**Re: Cross of Hope Lutheran Church, 6104 Taylor Ranch Road NW,
Certificate of Occupancy
Engineer's Stamp dated 7-27-03 (E11-D22)
Certification dated 3-10-06**

Re: Cross of Hope Church Grading and Drainage Plan
Engineer's Stamp dated 7-27-03 (E11/D22)

Re: Cross of Hope Church Grading and Drainage Plan
Engineer's Stamp dated 10-7-02 (E11/D22)

CROSS OF HOPE LUTHERAN CHURCH GRADING & DRAINAGE PLAN

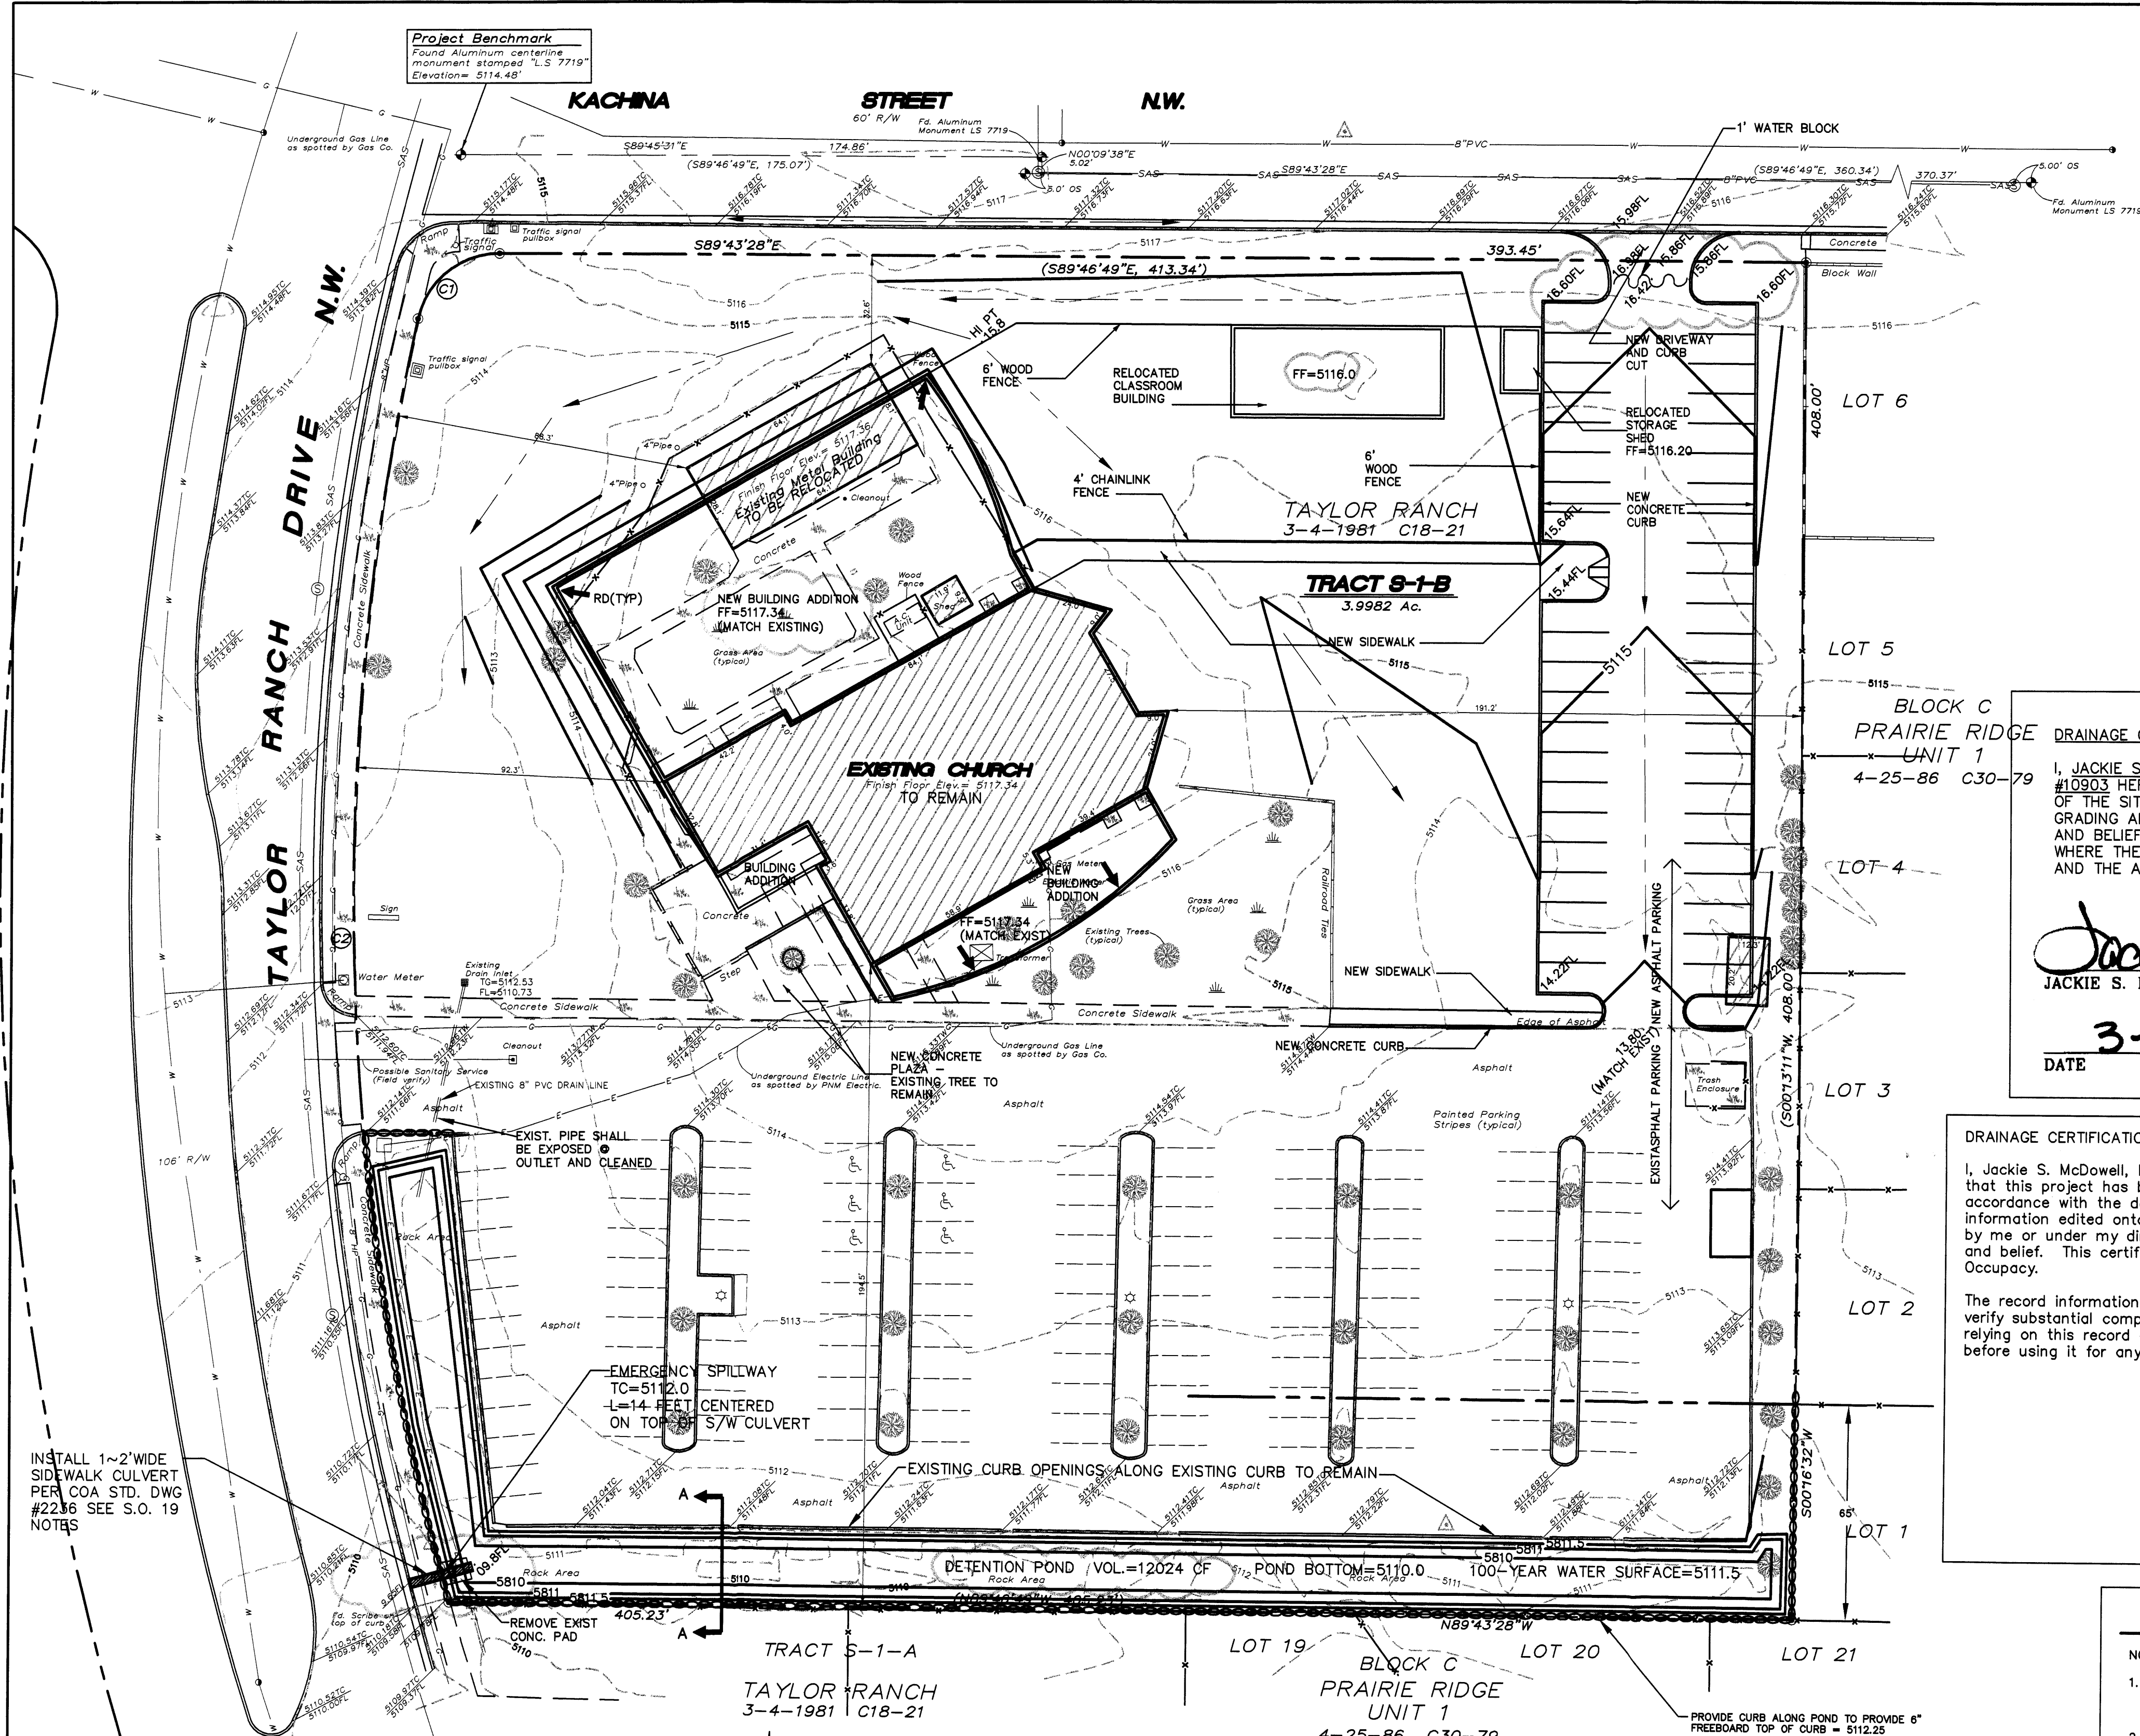
- The calculations infer that the site is undeveloped although you state on the plan that there is an existing structure and detention pond. Please rectify the calculations accordingly.
- How does the existing pond drain? Is there an outlet that must be removed or altered?
- Please show water surface elevation of the pond and provide a hard-lined emergency spillway. Keep in mind that a minimum of 0.5 feet of freeboard is required.
